To Kathryn Hughes
From Joanne McKay – Growth Lancashire
Subject Conservation Comments
Date 03/03/2023

Ref: 3/2022/0978

Proposal: Listed Building Consent for the internal re-ordering of listed building and later extensions to create a better 'flow' around the property. Alterations include: re-siting the kitchen, re-instating the former entrance doorway, changing the existing kitchen to a distinct entrance, boot room/utility, create third bedroom from large bathroom and circulation space, retain 'secret' doorway through original external gable, partial removal/demolition of internal wall to 18th century extension to allow a new small timber staircase. No alterations are proposed to the external appearance of the building.

Site Address: Little Blacksticks, Blacksticks Lane, Chipping Lancashire PR3 2WL

GROUND FLOOR PLAN

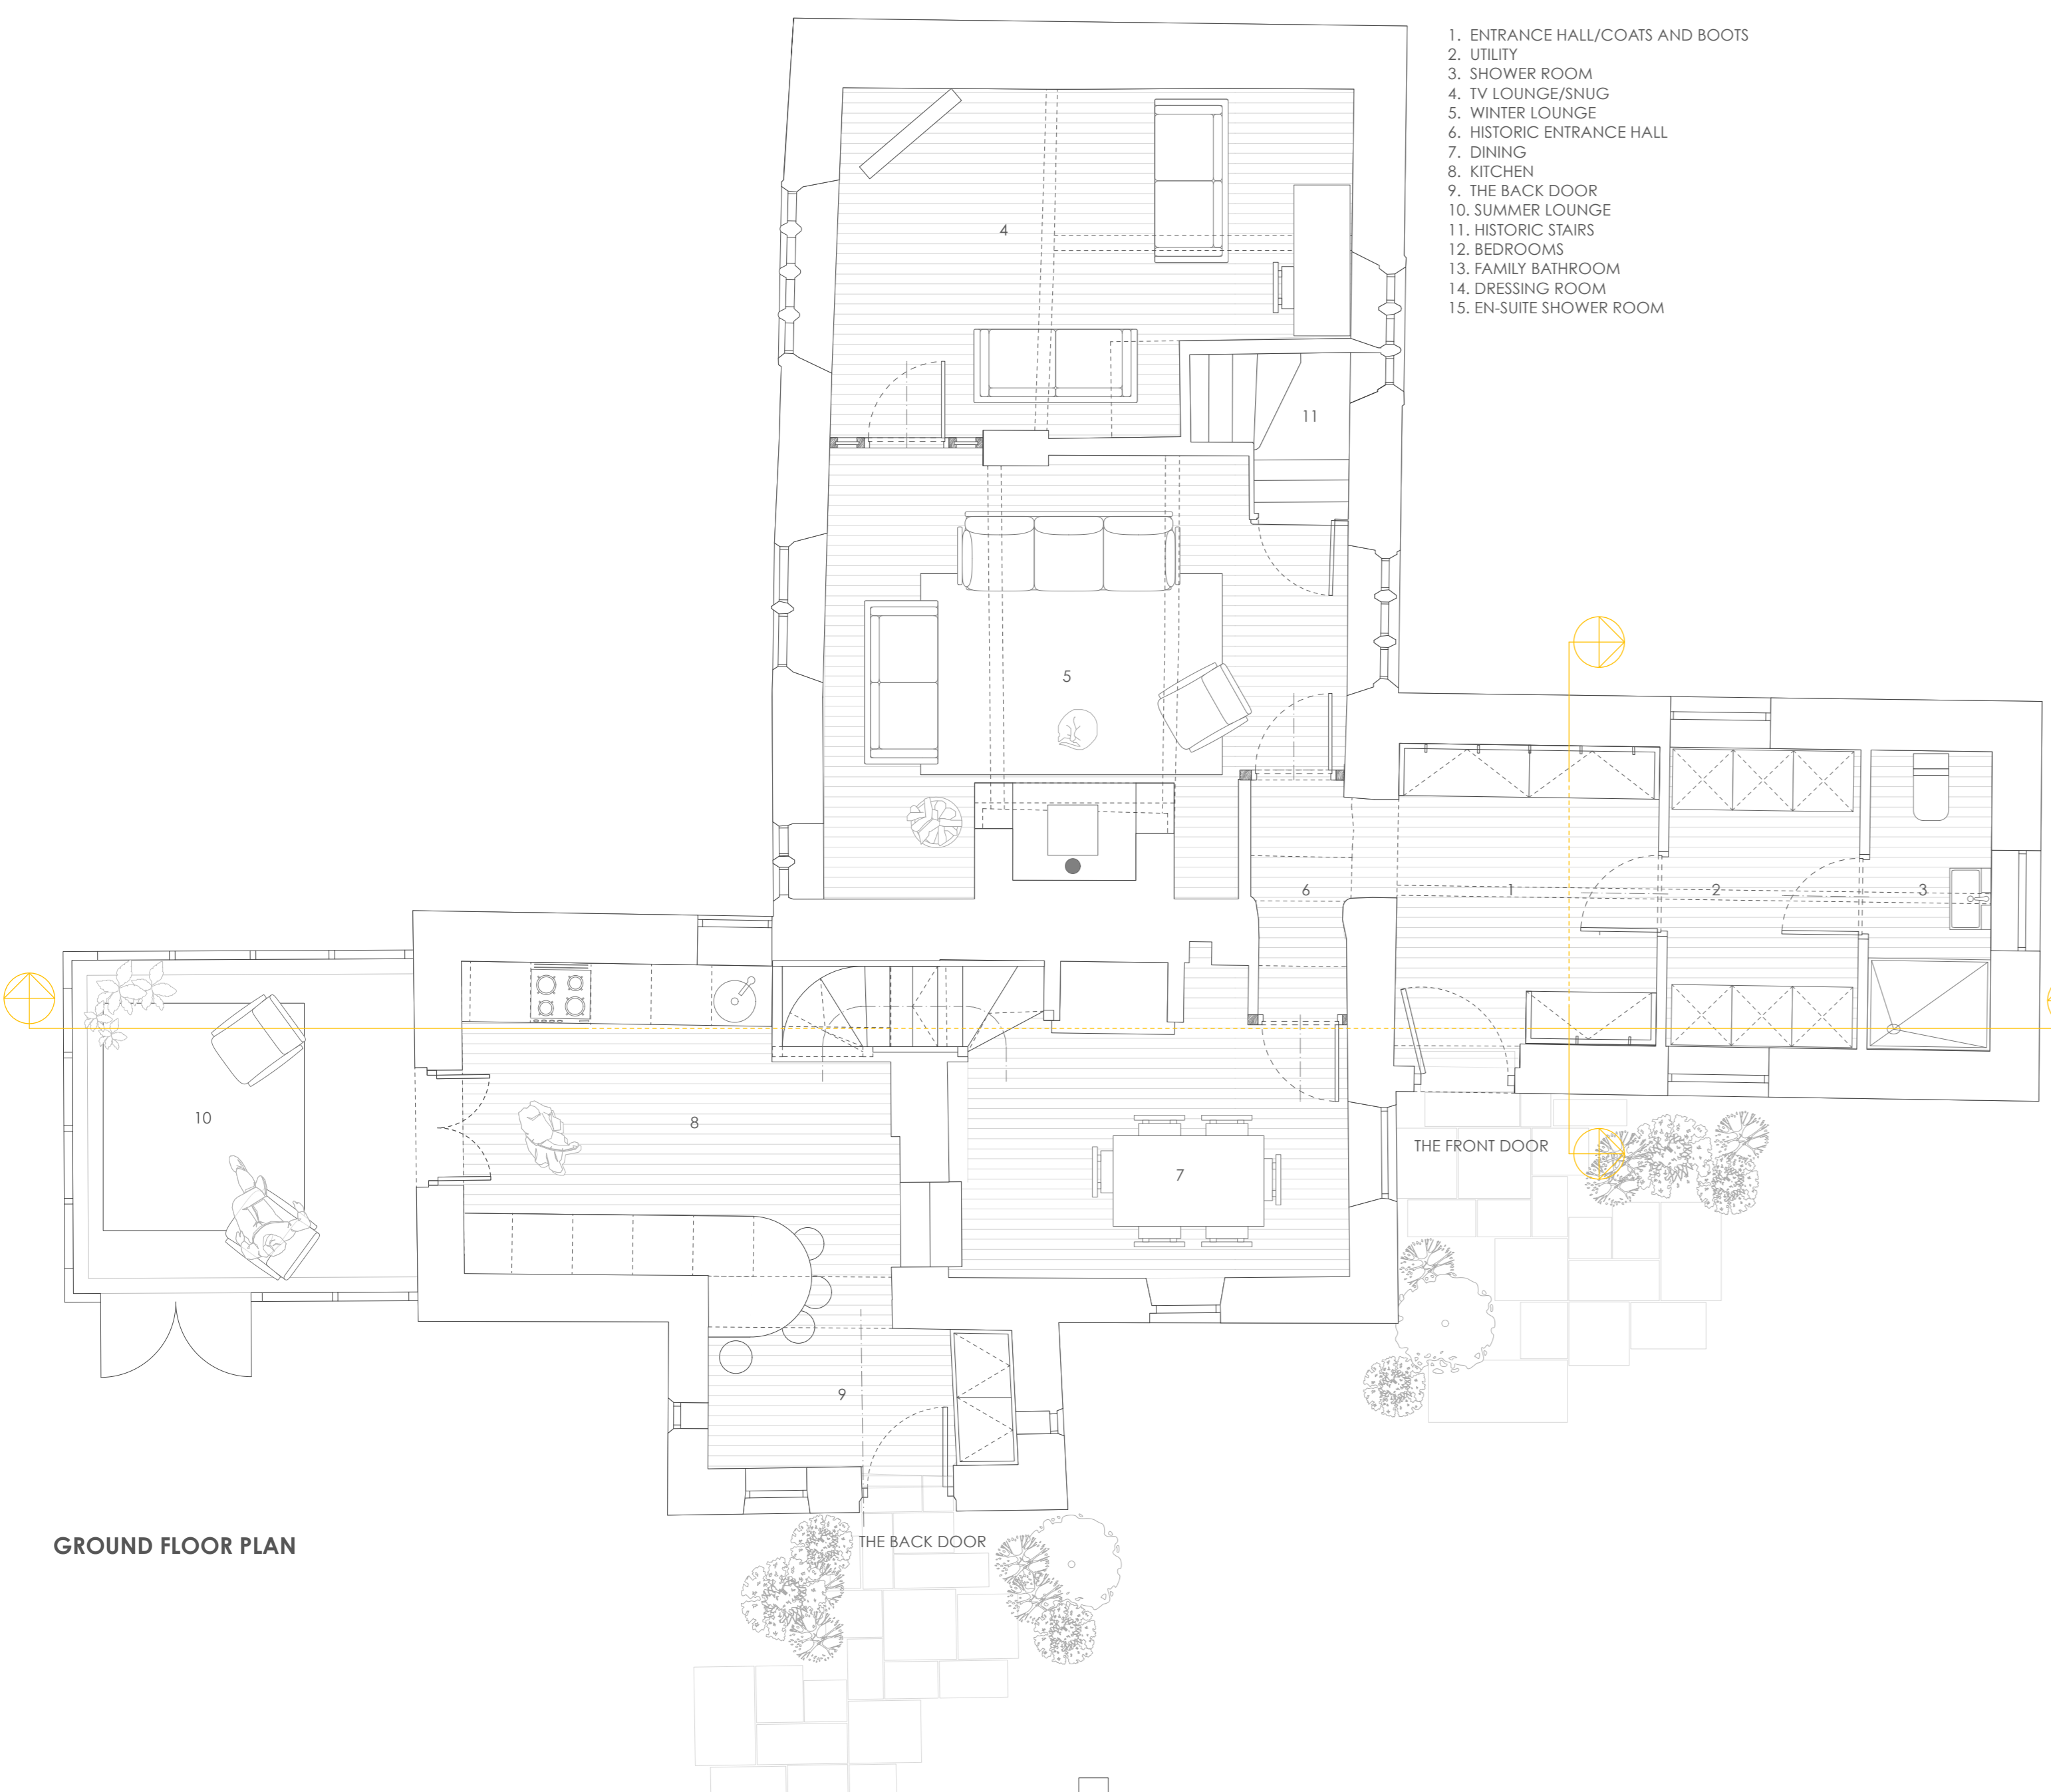
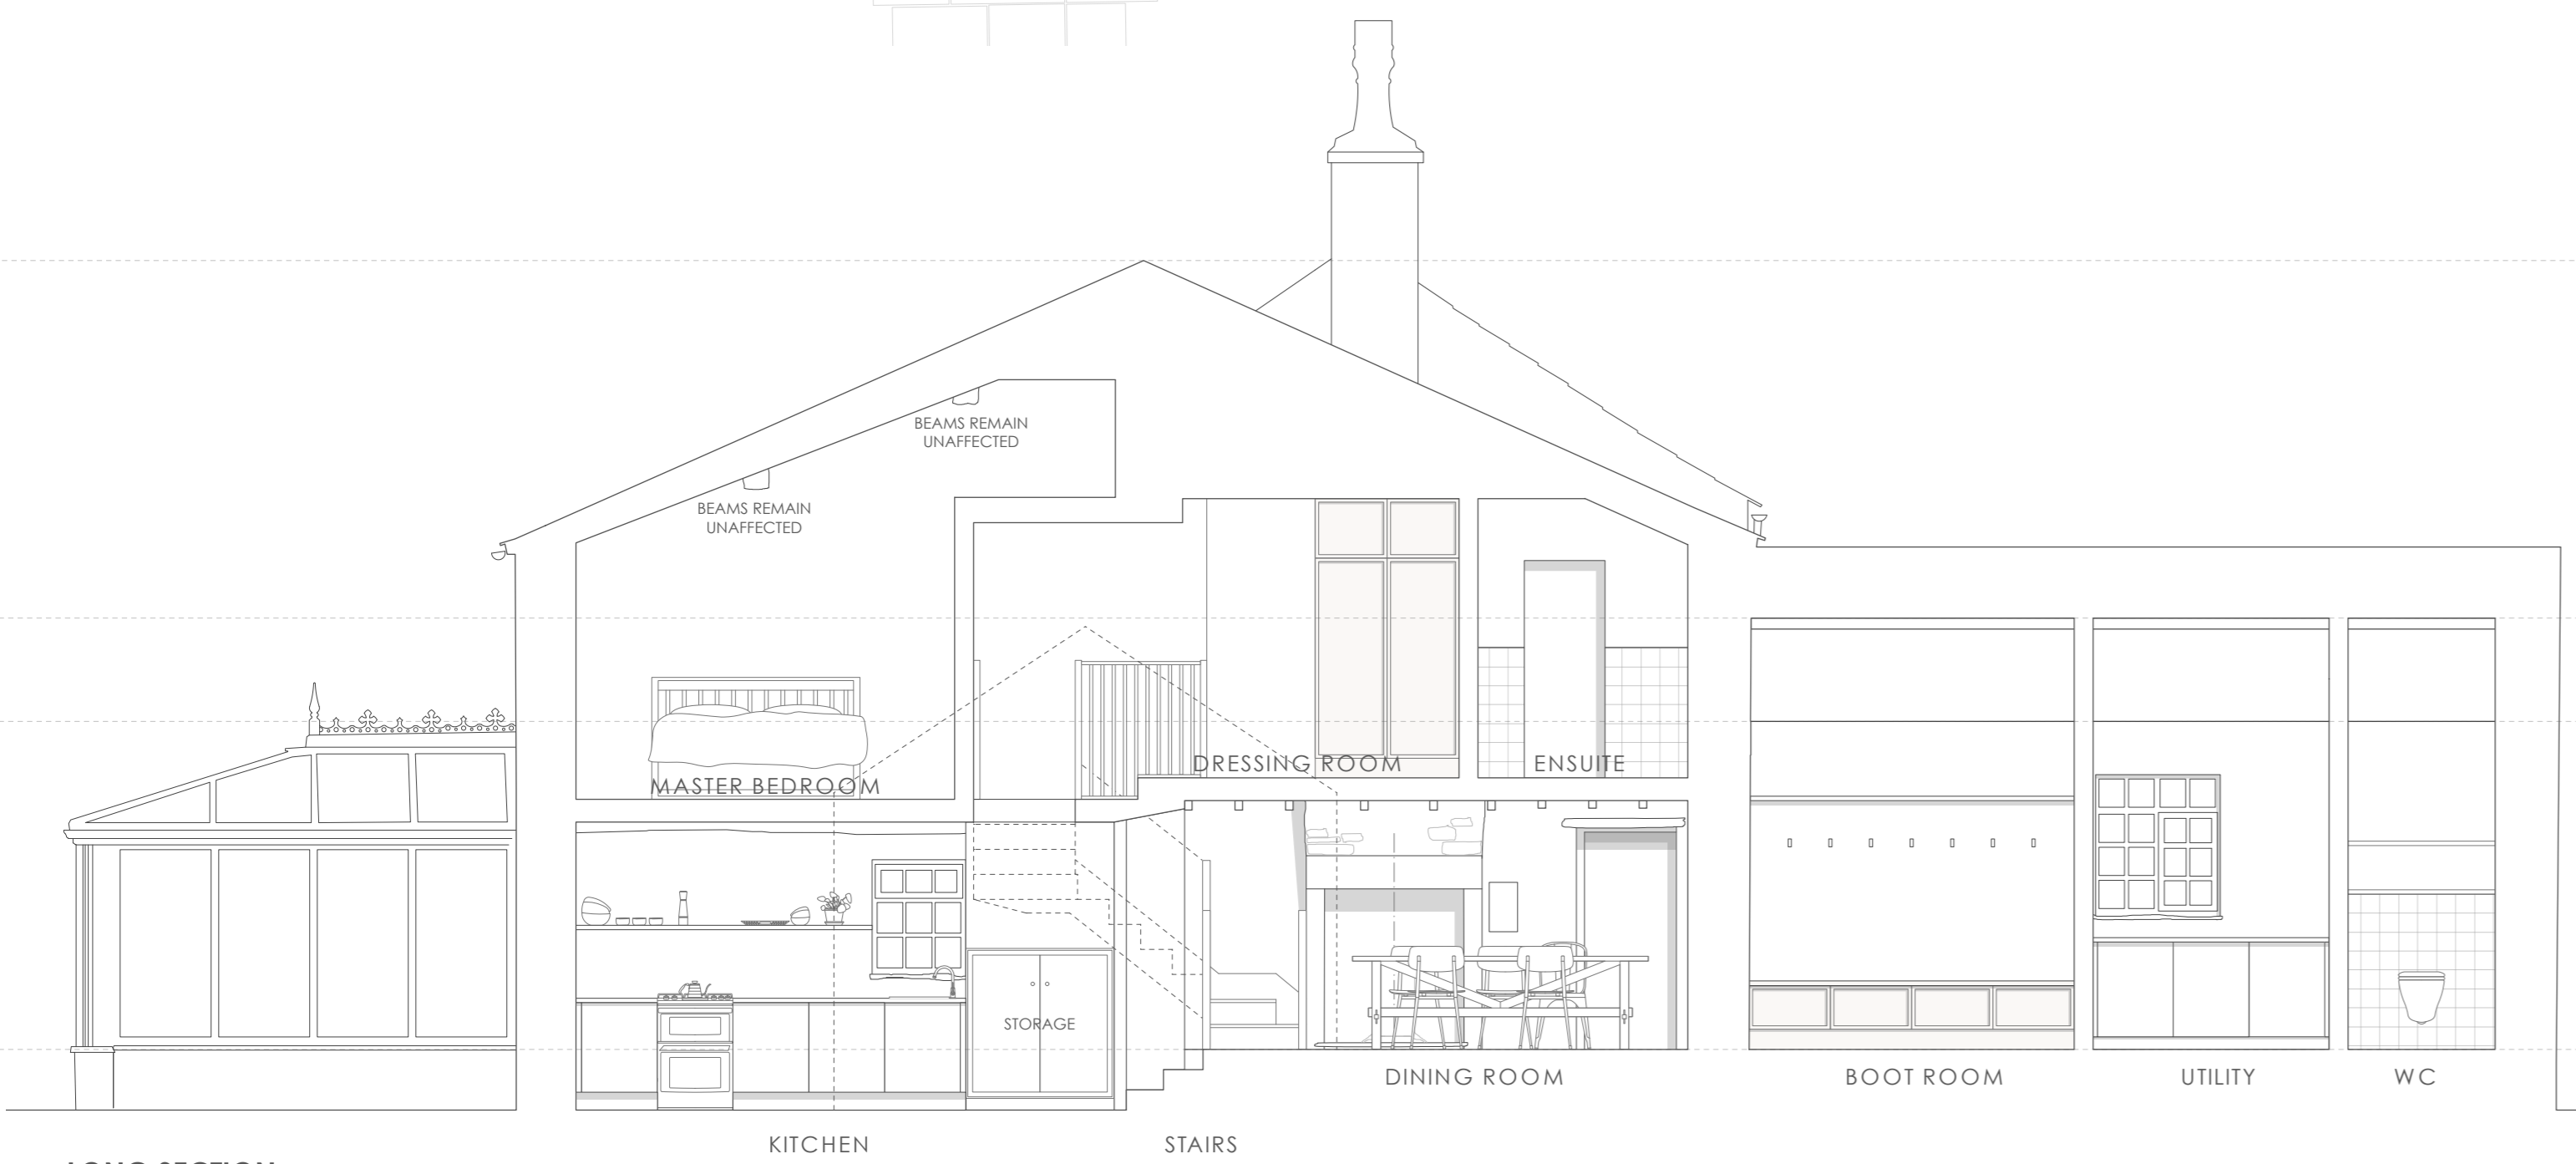
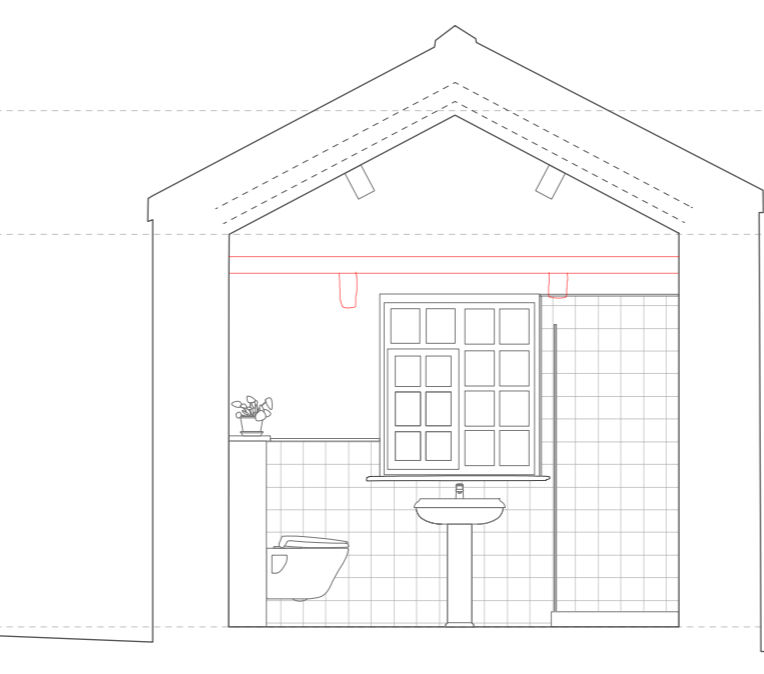
I raise no concerns in respect of the subdivision of the existing kitchen to create the boot room, shower and W.C. However whilst this part of the house is a later C19 extension it remains of some interest and as such, further details should be sought in relation to the beams and how they will be dealt with when subdividing the former kitchen. This probably can be dealt with via a suitable worded Condition.

Therefore, subject to further clarification of the works relating to the timber beams in the C18 & C19 element, the construction of the new curved wall and the changes in floor levels, it is likely that any harm caused as a result of the proposed works will be of a negligible scale, which could be adequately managed via the submission of a work methodology to confirm the detailed finishes and work procedures.
